Re: LVL Issue
Location: Lot 31 Honeycutt Hills (362 Adams Point Ct Angier, NC)
JDS Project No.: RDU2410850
Date of Inspection: 10/31/2024

A representative of JDS Consulting arrived on site to observe the issues reported to us by the client, which are presented, along with our recommendations, in this report.

sheet:
S2.0

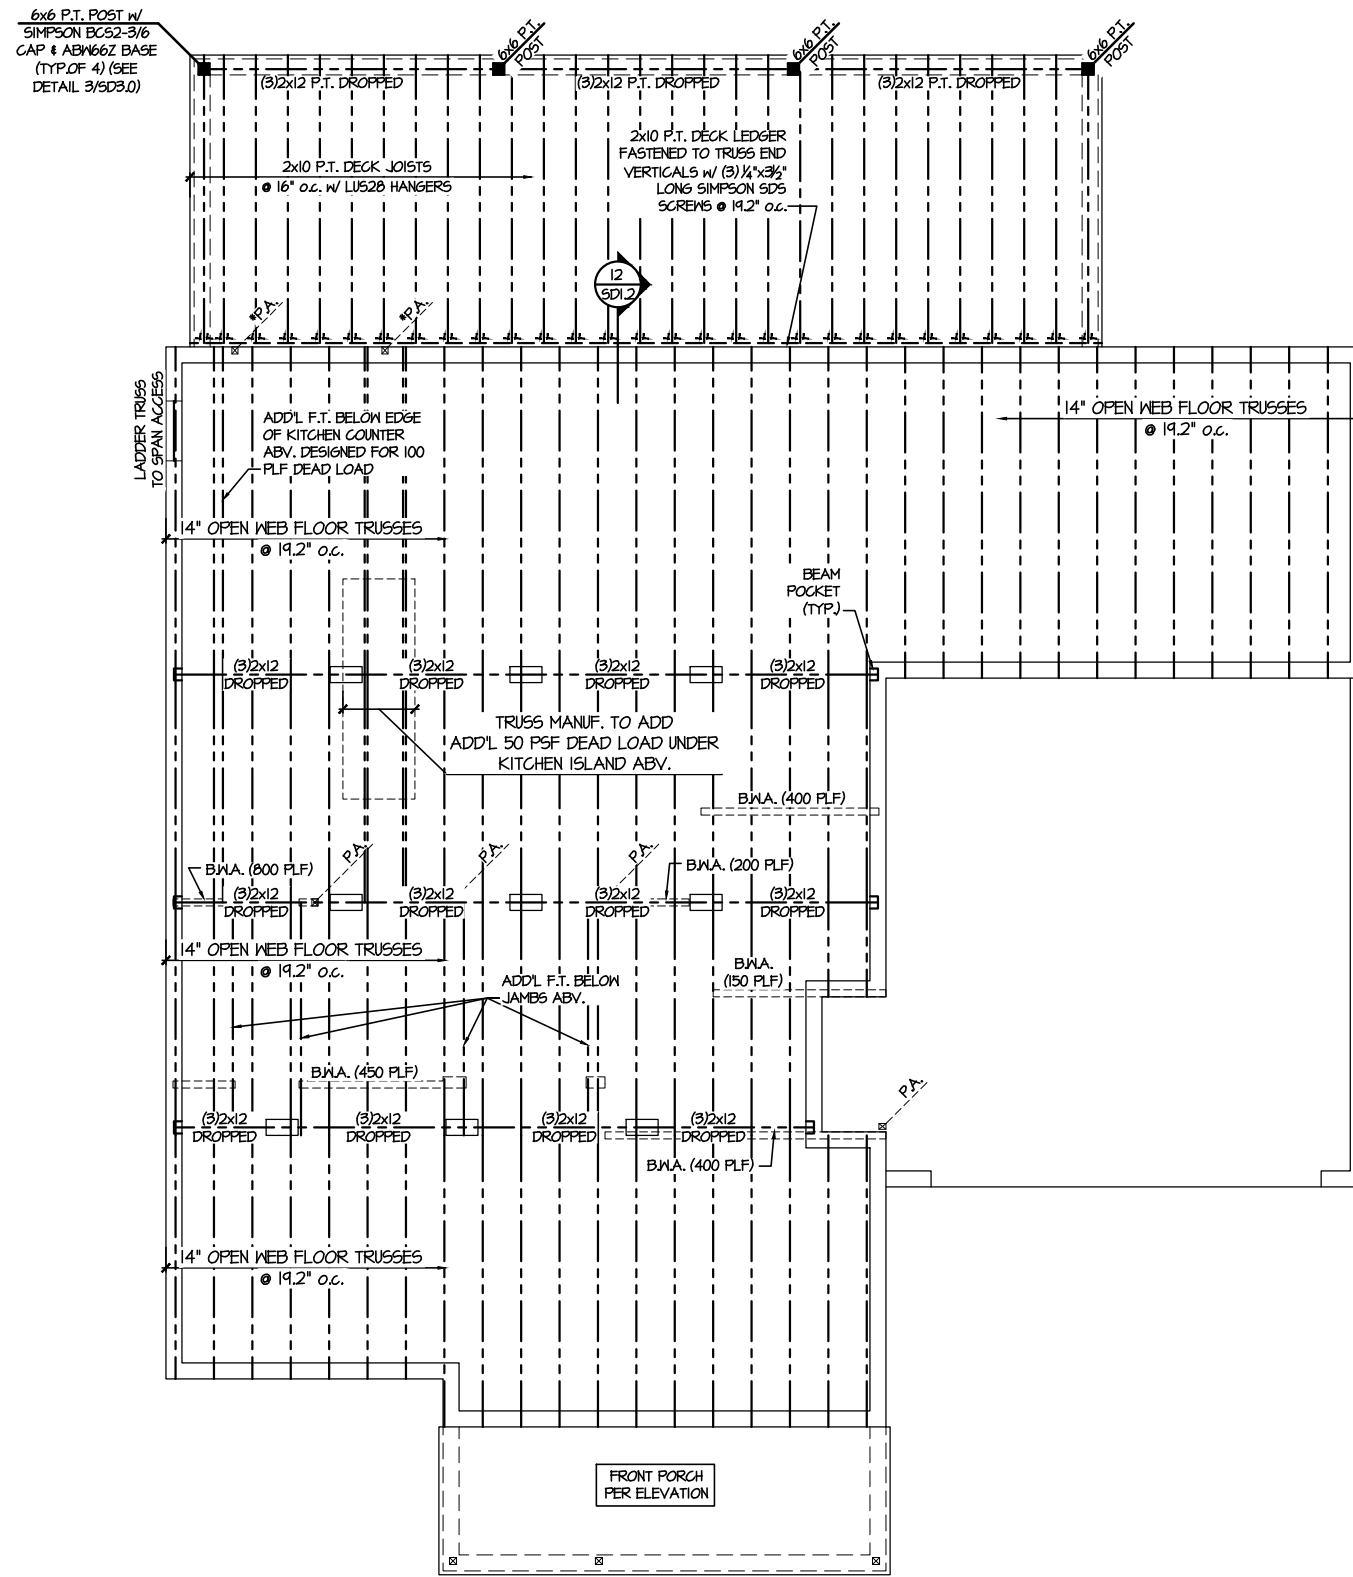
The client requested an evaluation of alternate framing at the left garage wall. The plans call for the (3) ply 1-3/4"x18" LVL beam directly to the rear of the garage front door to bear on (6) ply 2x4 column. There is not sufficient clearance at the location, instead the builder has hangered the beam to a (2) ply 18" LVL with a Simpson HGUS5.50/14, the carrying beam spans approximately 5'-8" and is supported by a (6) 2x4 column at the front side and a (5) 2x4 column at the rear.

Based on our observations and review, the (2) 18" LVL is adequate to support the loads from the (3) ply girder, however the hanger at the location is not adequate. Install (2) Simpson GA1 angles above the existing hanger on each side.
